**APPLICANT'S COMMENTS ON THE ANGLIAN WATER
WRITTEN SUBMISSIONS AT DEADLINE 6**

PINS project reference: WS010005

PINS document reference: 16.2

The Applicant's response to the 'Written summaries of oral contributions at hearings' submitted by Anglian Water at D6 (REP6-019)

Figure ESA5.1 Scale: 1:2,500@A2

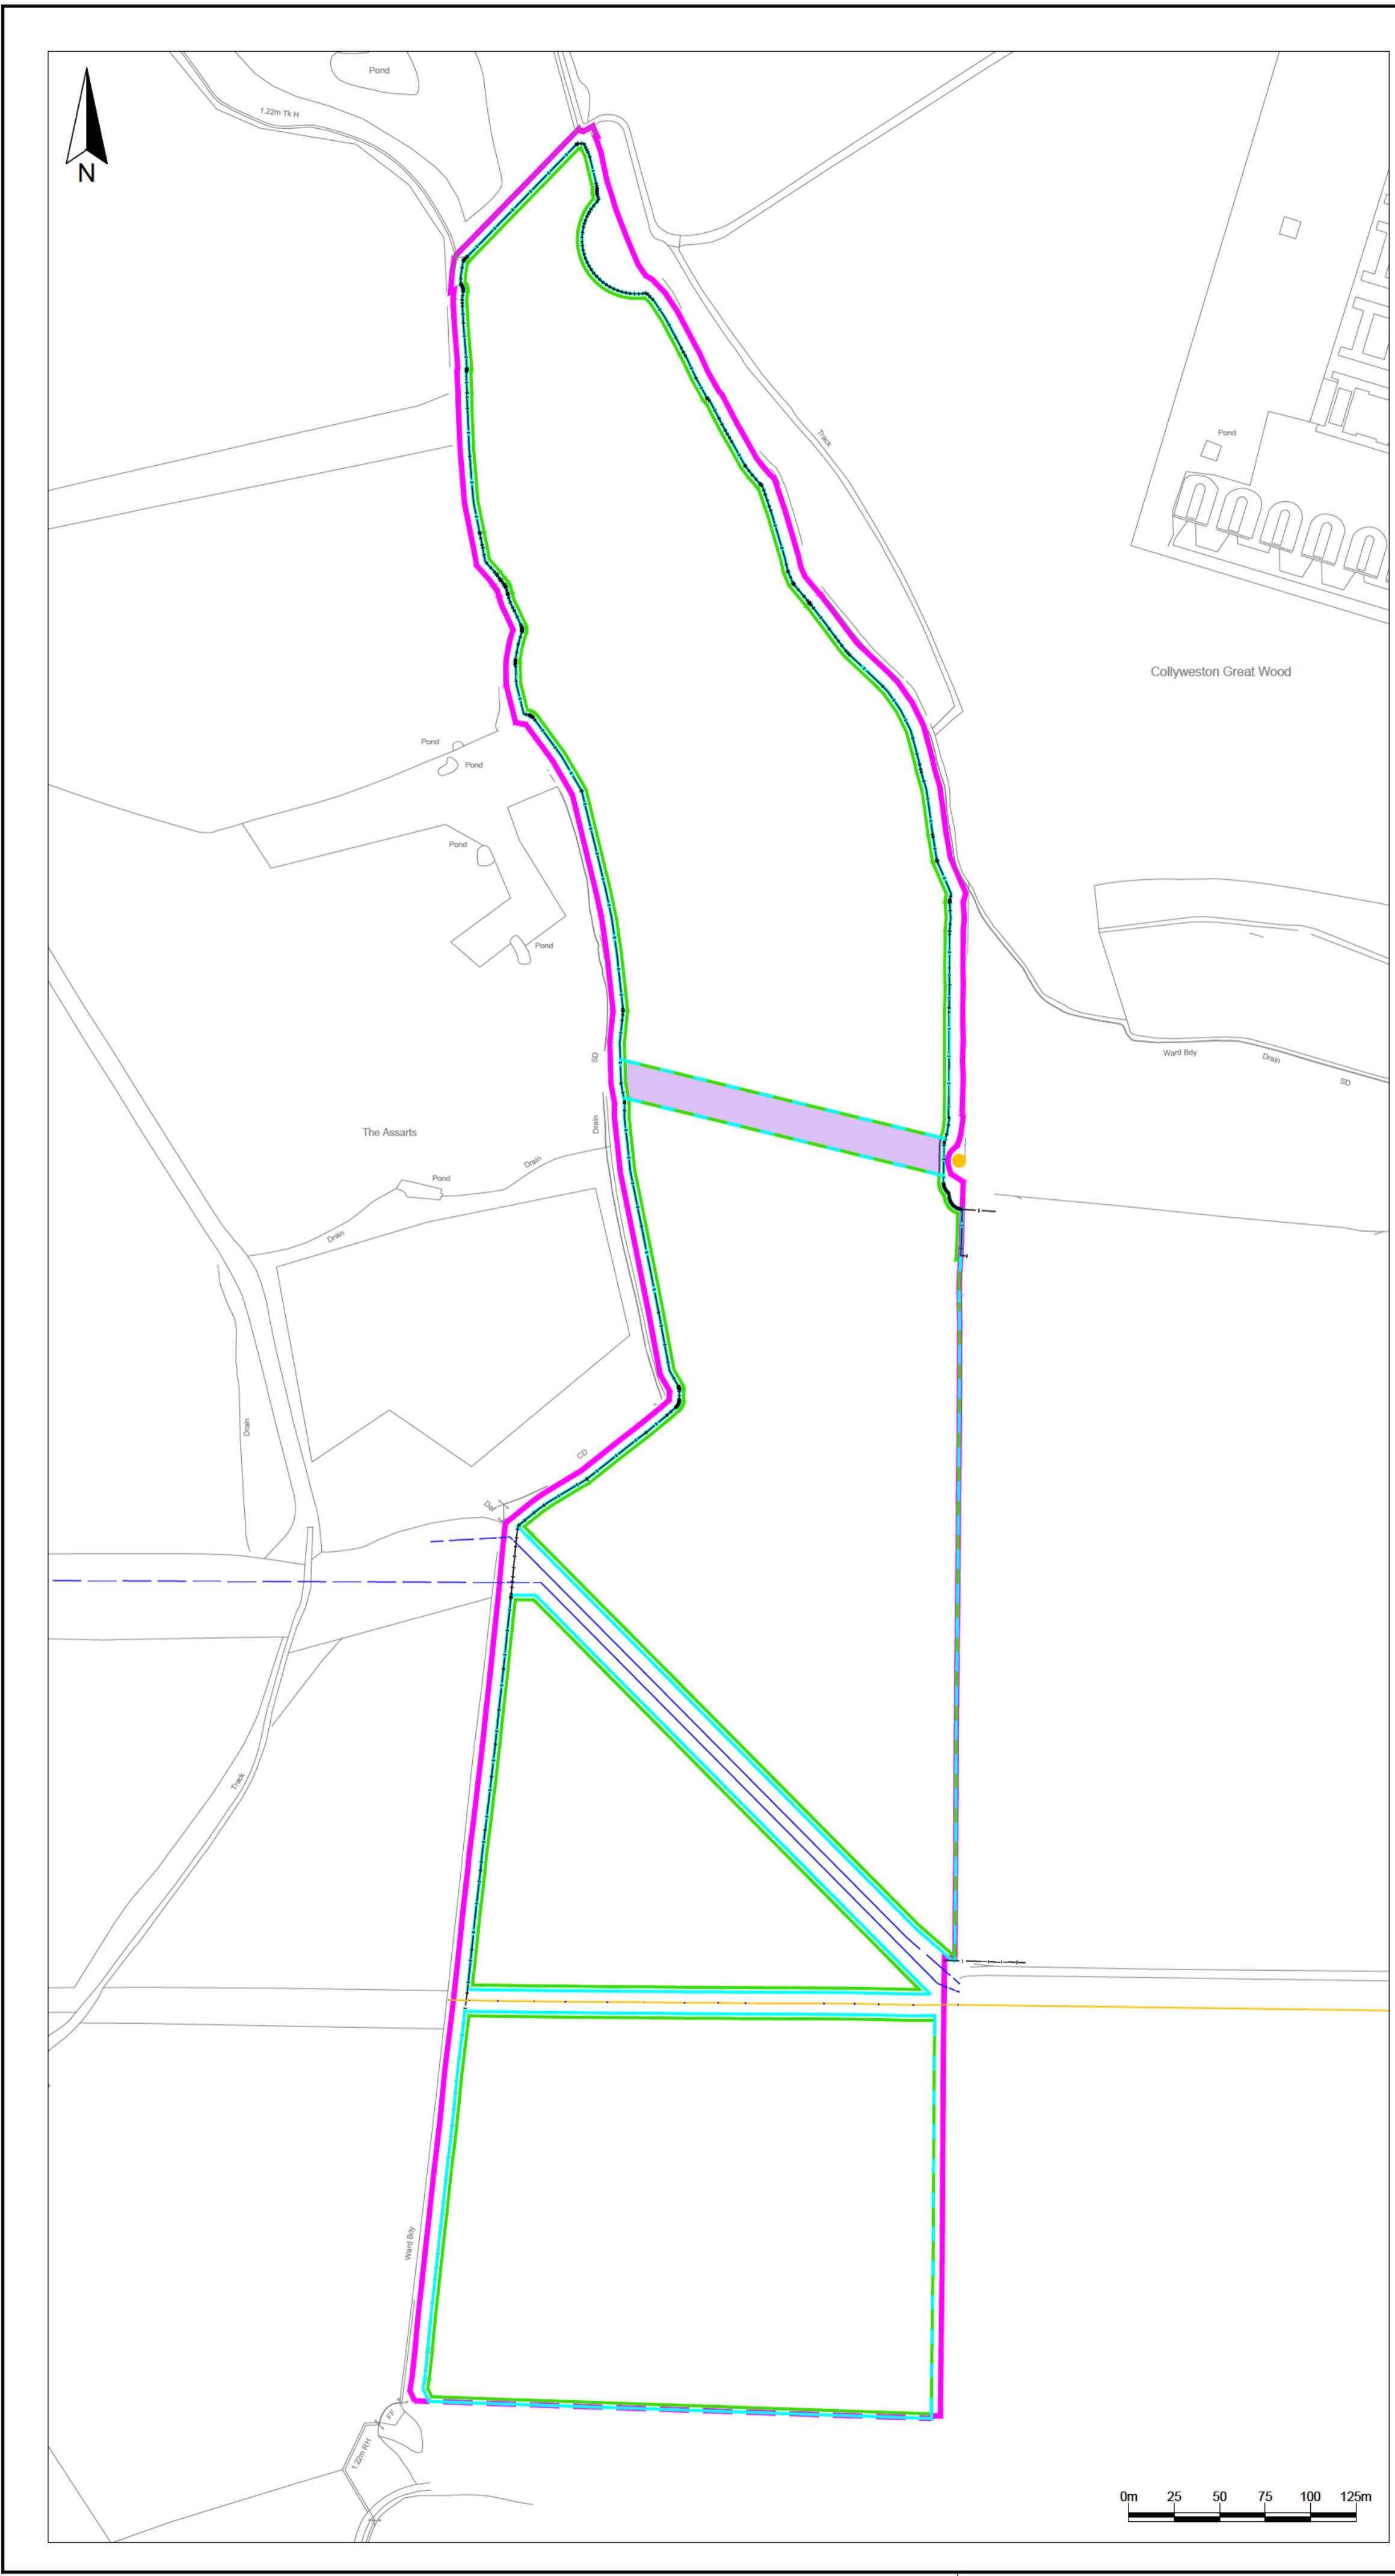
Paragraph number	Comment in the submission from Anglian Water	Response from the Applicant
		a total distance of 9.5m from each pipe based on the original design of the standoff distances.
5	AW emphasised the implications of there being two parallel pipes within the landfill and a landfill containing low level, hazardous waste with potential for contamination.	The Applicant considers that it is important to state clearly that the water pipes would not be located within the landfill. The pipes would remain located in natural ground, between two separate areas of engineered containment landfill.
6	Mark Froggatt, AW's Chief Engineer, stated AW's fundamental position of wanting to protect both the public's drinking water and AW's assets. The fact is the main was diverted last time and AW sees no reason why the same should not apply this time. AW had engaged with the applicant (although it seems MF's latest email had not been received).	<p>Augean is also committed to protecting the public and to ensure that the assets of third parties are not affected hence why it has undertaken comprehensive assessments of all issues raised during the application process.</p> <p>The water main was diverted as part of the previous development (including mineral workings and the current landfill) as there was no proposal to landfill in separate areas, only to deposit waste in a single engineered landfill area and so diversion was the only option.</p> <p>The information reported to have been provided by AW on 1 June was not received by the Applicant until 21 June 2022 despite chasing it up with AW immediately following the ISH. The Applicant's response to the plans and associated information provided by Anglian Water on 21 June 2022 is provided at document reference 15.2.6.2 (REP6-017).</p>

9	<p>AW would wish to see the applicant's calculations (not seen before) that have been made to assess the potential for long term exposure of ground conditions with extreme weather conditions or even swell, which will possibly lead to stress in that pipe work, along with vehicle movements, excavation, vibration, etc. All these things can actually impact upon our pipeline, whether it's in a fragile or a semi fragile state, or whether it's in a robust state. NB though we have to consider the fact that the moment this pipeline sits within an agricultural land and the only loadings it generally has from its stable condition is occasional</p>	<p>The assessments and calculations regarding the potential effects of the proposed development on the structural integrity of the pipes are presented in the Pipeline Risk Assessment report (AS-025) submitted with the request for a Non Material Change to the application. The risk assessments demonstrate that the calculated crater diameter following a catastrophic failure event and the standoff distance needed so that there is no effect from the landfill activities on the structural integrity of the pipes are less (ie shorter standoff distance) than the standoff proposed in the original design as submitted.</p>

Route 3

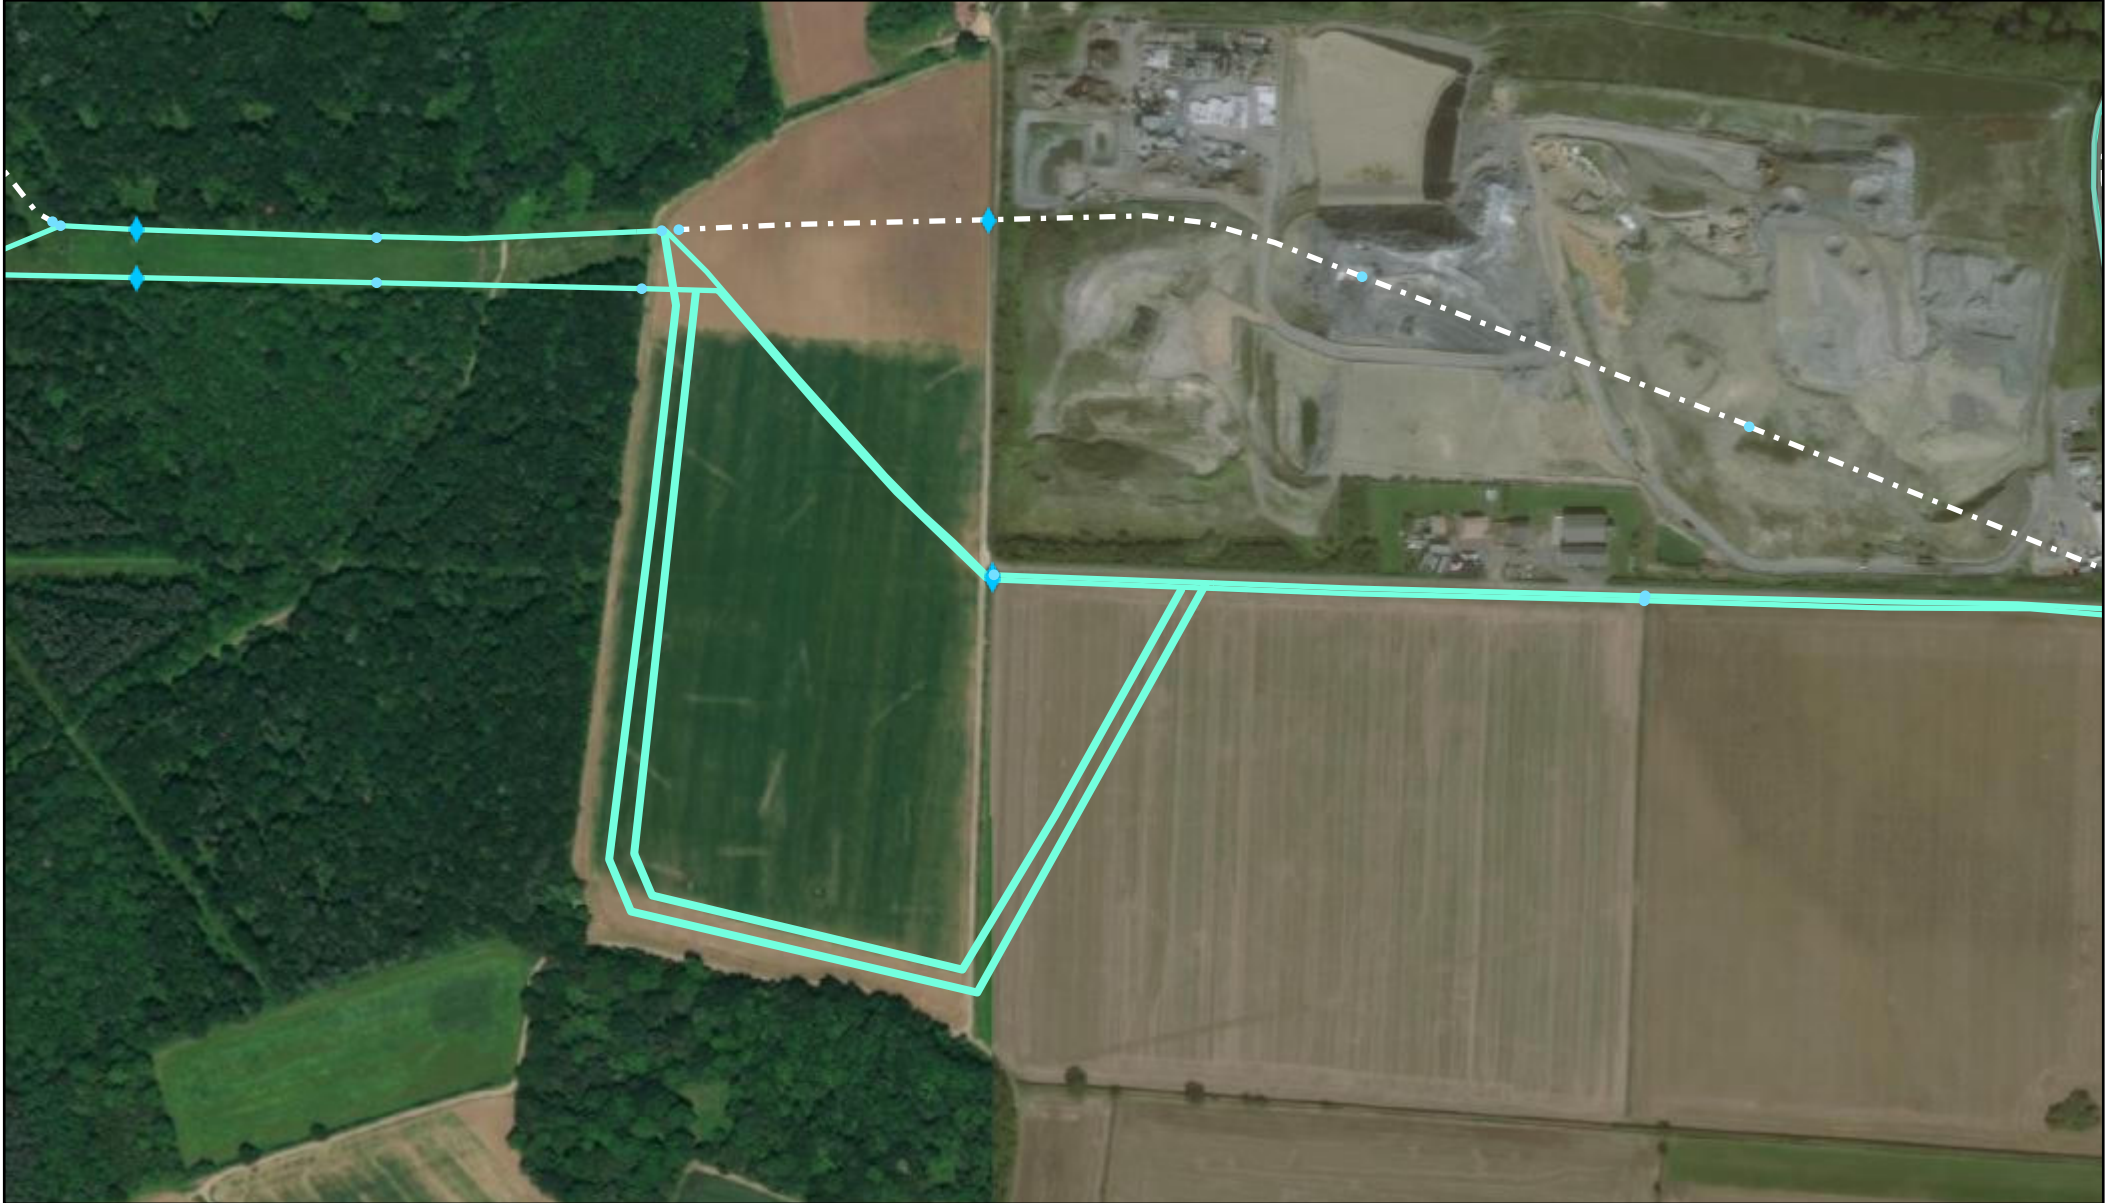
Paragraph number	Comment in the submission from Anglian Water	Response from the Applicant
	<p style="text-align: center;">Route 2</p>  <p>Route 3: the least environmental impact option but does mean that the land take for the Application would be less.</p>	<p>medium term the grassland boundary which has been demonstrated by the ecological surveys to host a diversity of flora and fauna.</p> <p>It is noted that no change is proposed to the majority of the length of the pipes which currently are located adjacent (within 15m to 20m) and to the south of the current ENRMF landfill site which is formed in the same geology, based on the same construction principles and is filled with the same types of waste (LLW and hazardous waste).</p> <p>This proposed diversion is for a total length of approximately 1,050m for the outside pipe and 1,000m for the inside pipe. 340m of the diversion crosses agricultural fields and the remaining 710m is located inside the areas proposed for landfill construction along the southern and western sections of the proposed western extension. The majority of the length of the diversion, excluding that in the agricultural field, would be adjacent to the landfilled areas therefore any perceived benefits of this as an option rather than leaving the pipes in situ are not apparent.</p> <p>The proposed development is a NSIP and the need for the void and the space that it provides is nationally significant as explained in the Planning Statement (APP-103). If any diversion were to be contemplated within the confines of the proposed development, this would reduce the void available to the disbenefit of being able to manage safely the nation's waste.</p>
